Permit Number: 050957

has permission to Build a 26' x 30' Detached "b" house"

AT 47 SUNSET AVE

**Dept:** Building**Status:** Approved with Conditions**Reviewer:** Tammy Munson**Approval Date:** 0912012005**Note:****Ok to Issue:**

FIRST FLOOR + FOUNDATION LAYOUT

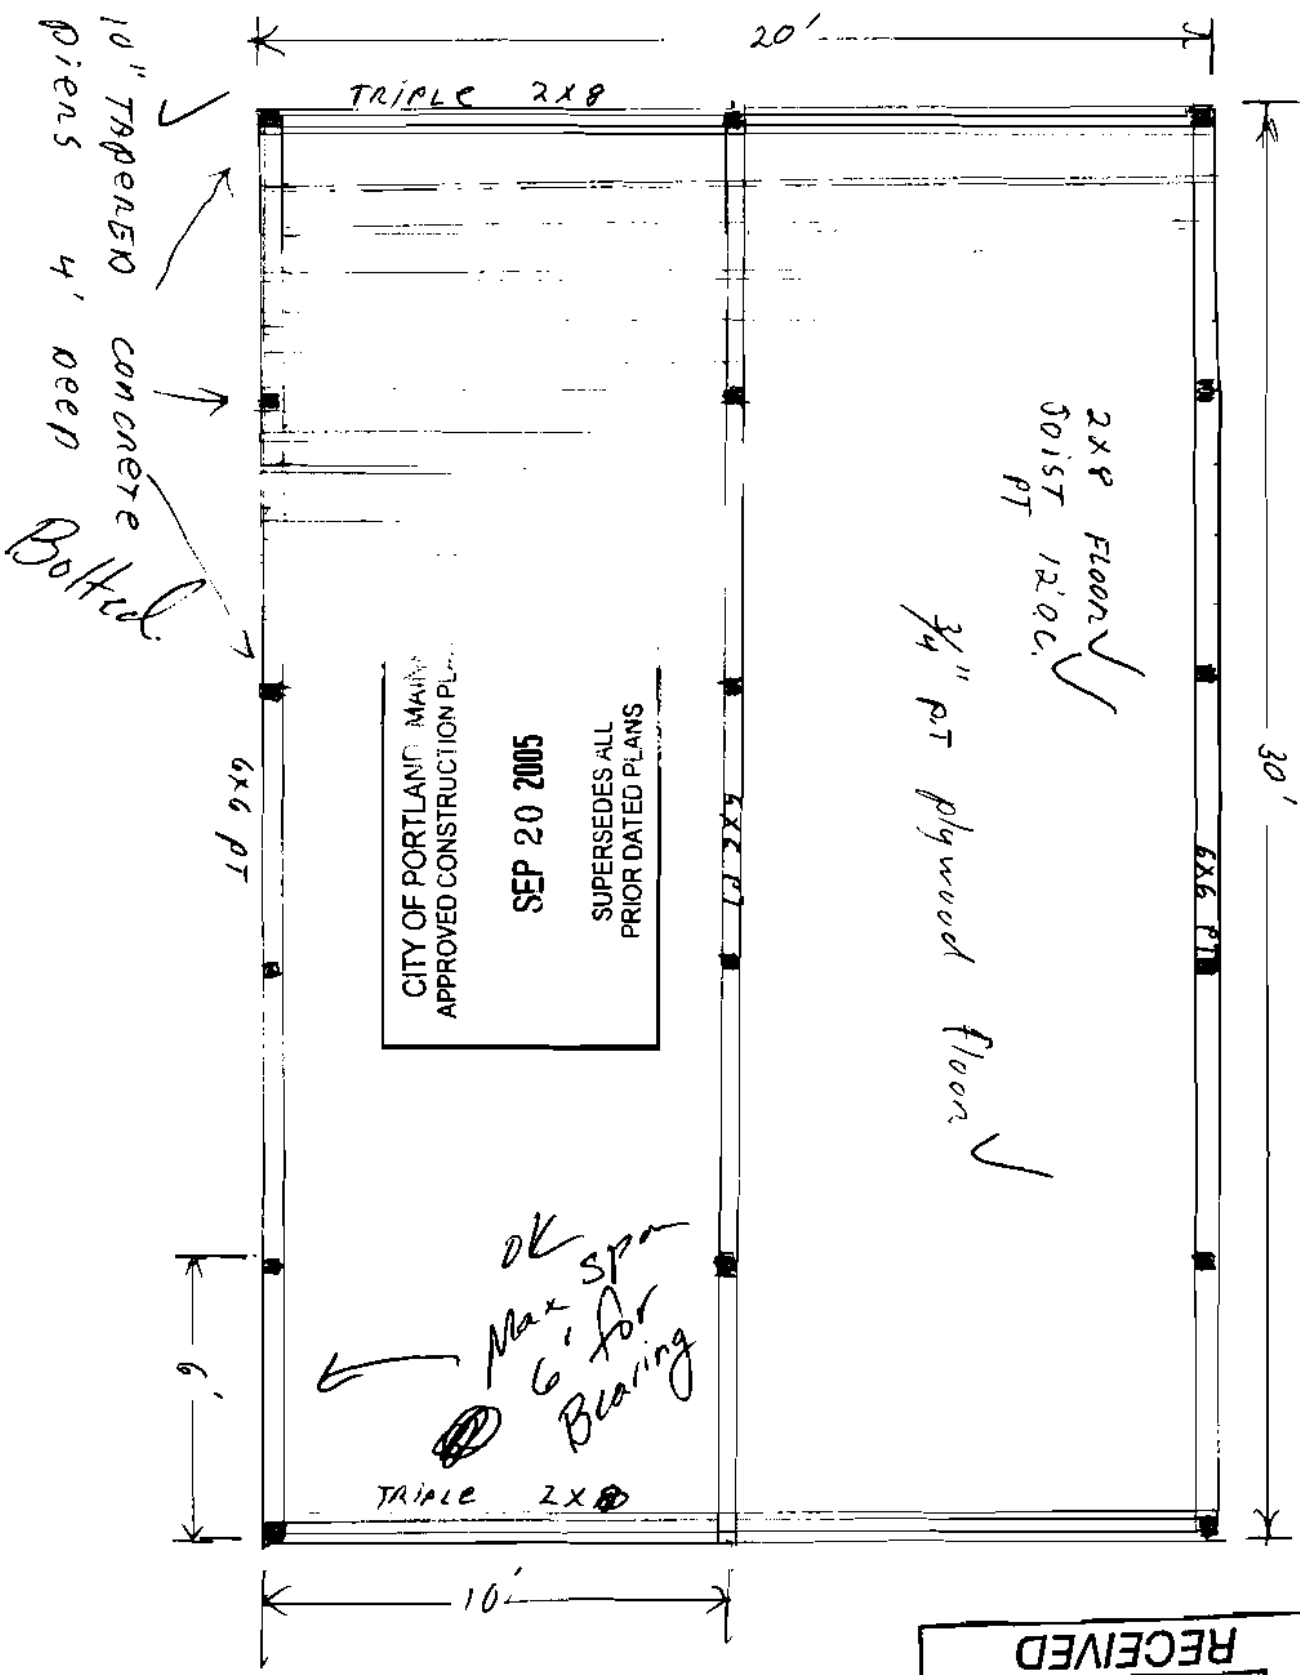
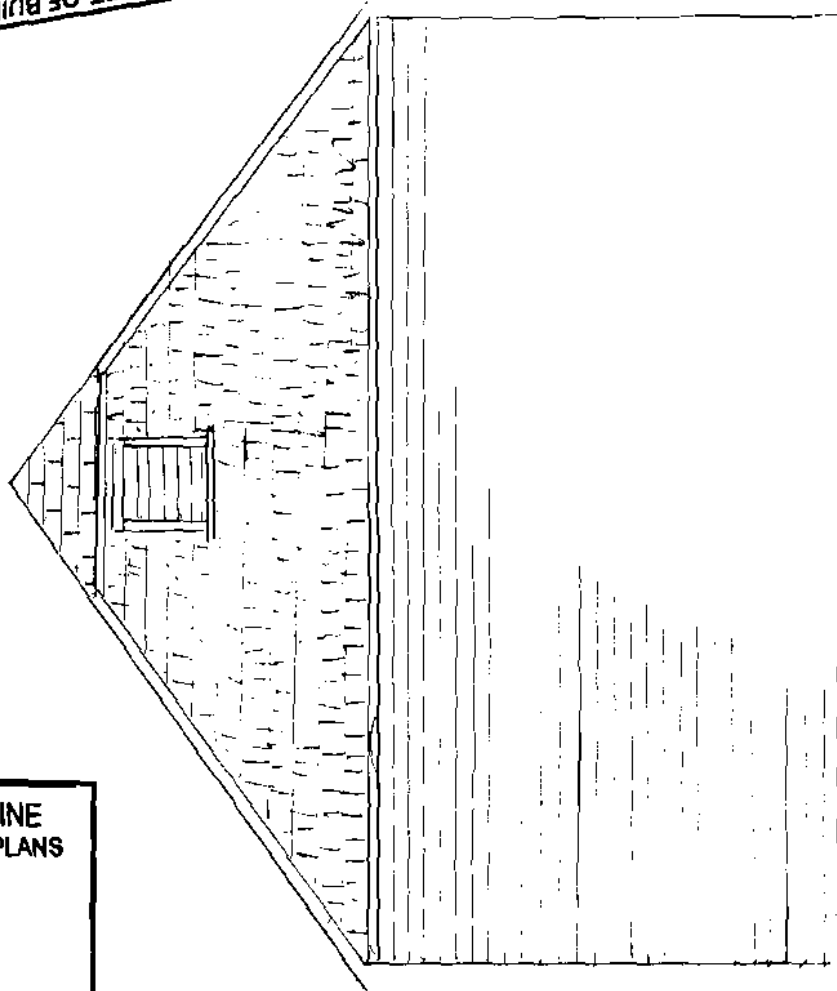
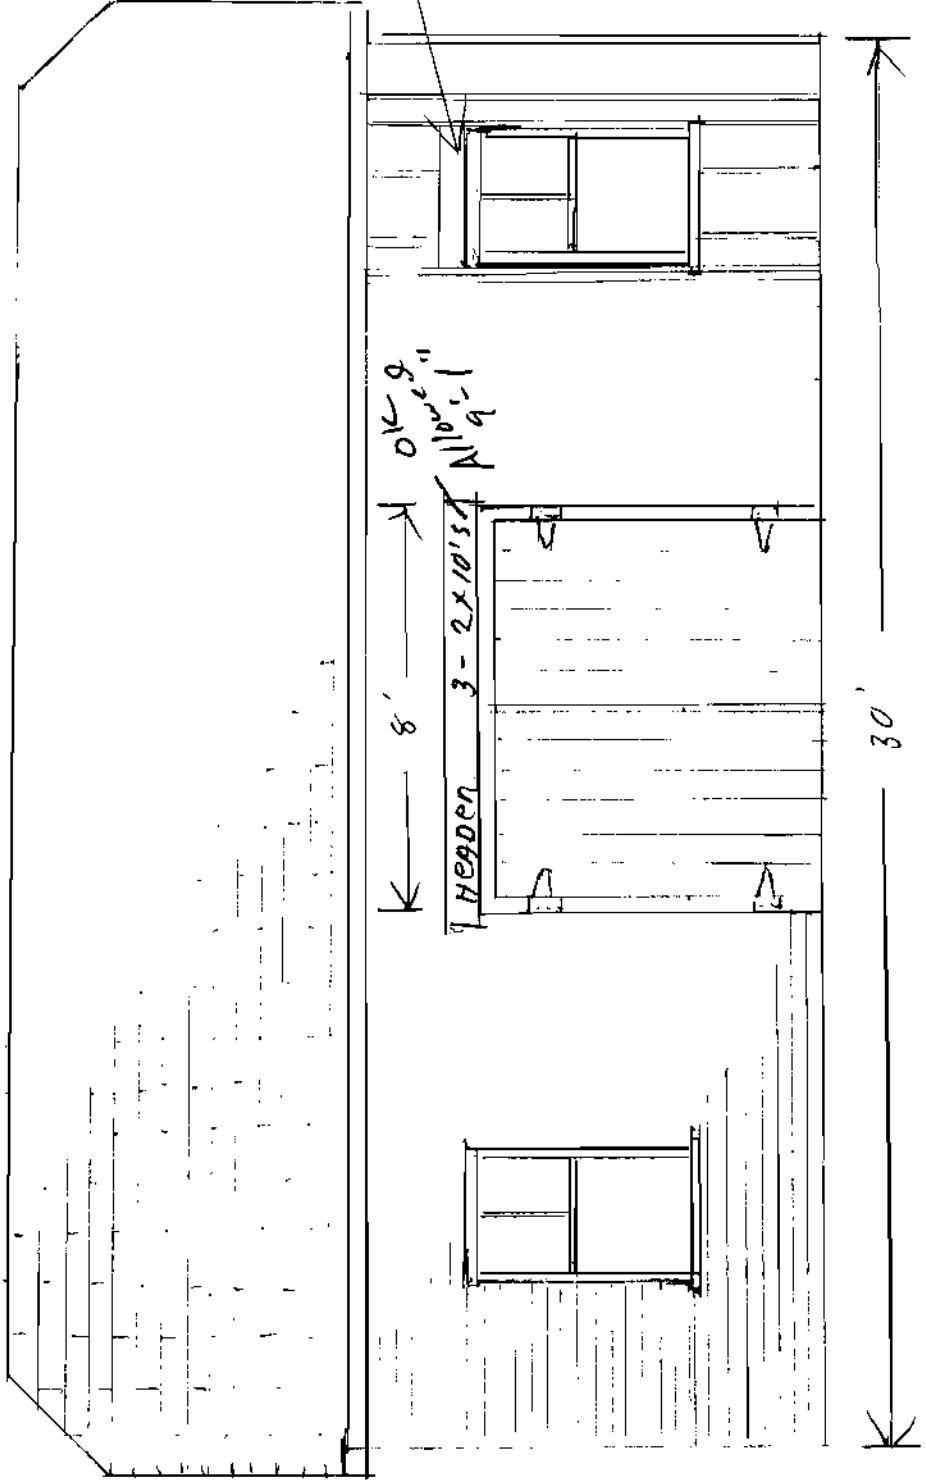
1) An attic access measuring a minimum of 22" x 30" must be installed.

8/5/05-tmm: spoke w/builder - went over what was needed.

9120105-tmm: rec'd revised plans - ok to issue
